Your Ref: OWPC22311
Our Ref: R/72/19/PL 02-04-2019
Please ask for:
Mrs A Gardner

Demolition of existing garage & store on existing dwelling & construction of 2 new dwellings in rear garden.

6 Manor Road Rustington

BLOCK PLAN: 6 MANOR ROAD, RUSTINGTON.

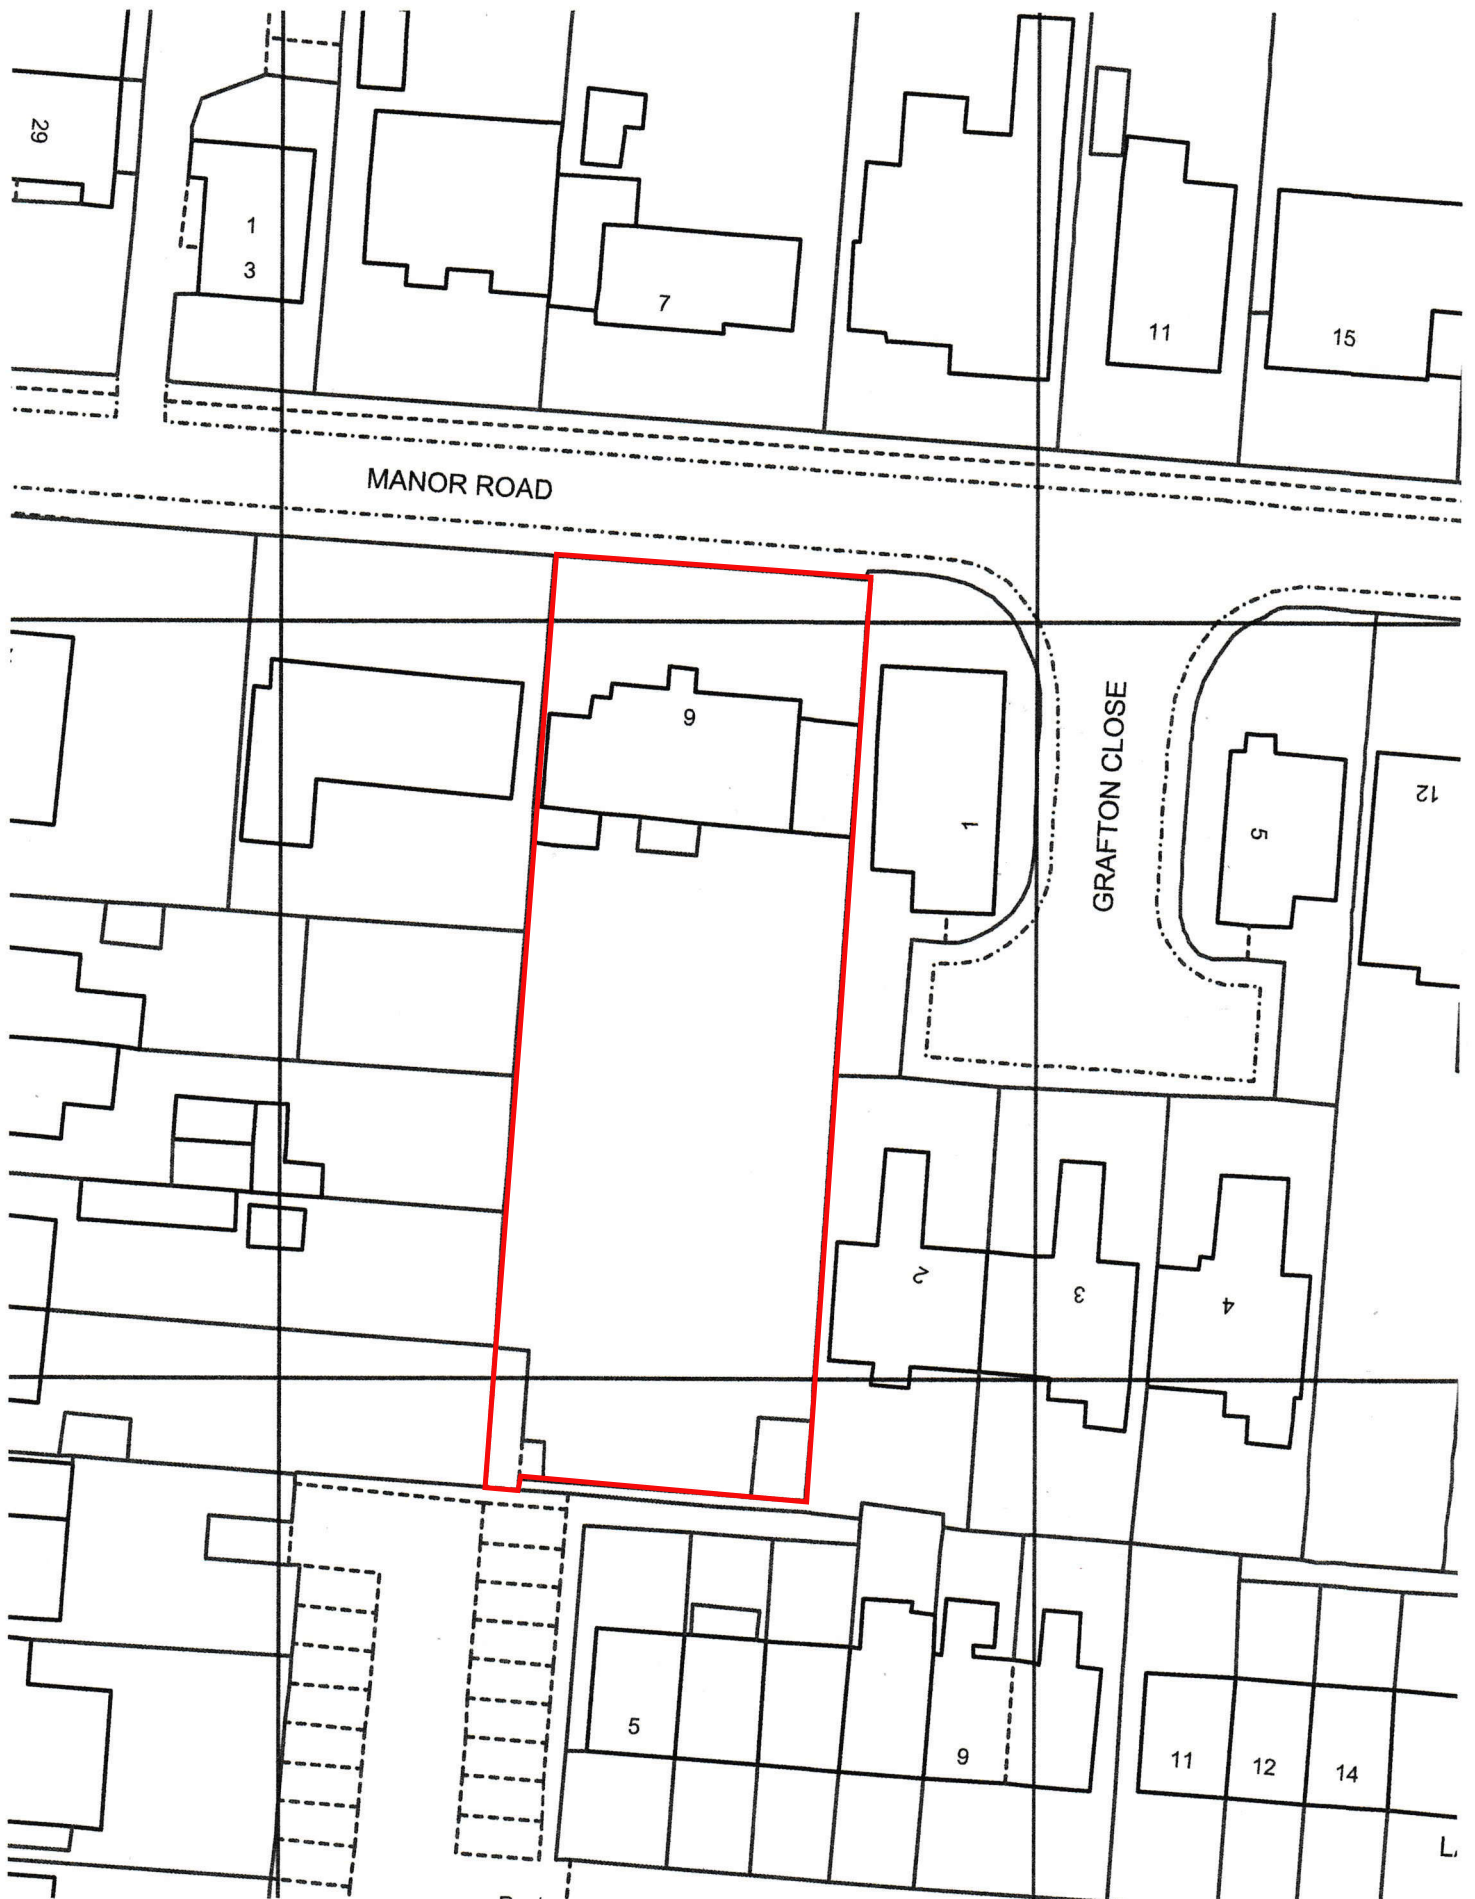
- 1. The design statement shows a ridge height of 6.2m but the elevation drawing shows a height of 6.62m a difference of 0.42m.*
- 2. The site drawing roof plan shows barn hips at opposite ends of each property, however the elevation drawing shows full height gable ends and no hips.*
- 3. The proposed site plan shows a dimension of 1.92m between our property and the nearest chalet bungalow and a figure of 0.9m to the boundary, which leaves a figure of 1.02m from our property to the boundary. The actual dimension from our property to the centre line of the boundary is 0.87m approx. Is the figure of 1.92m between properties correct.*
- 4. On the first floor plan in Bedroom 2 a side window is shown, however the elevations fail to show a window.*

We have concerns with the close positioning of the proposals to our bungalow and being overlooked. Provision of obscure glass to the two small windows closest to us, which we believe are bathrooms, would be welcomed. The front of the new chalet bungalows will sit forward from the front of the main build line of the bungalows 2, 3 and 4 by just over 3.0m which we feel is excessive.
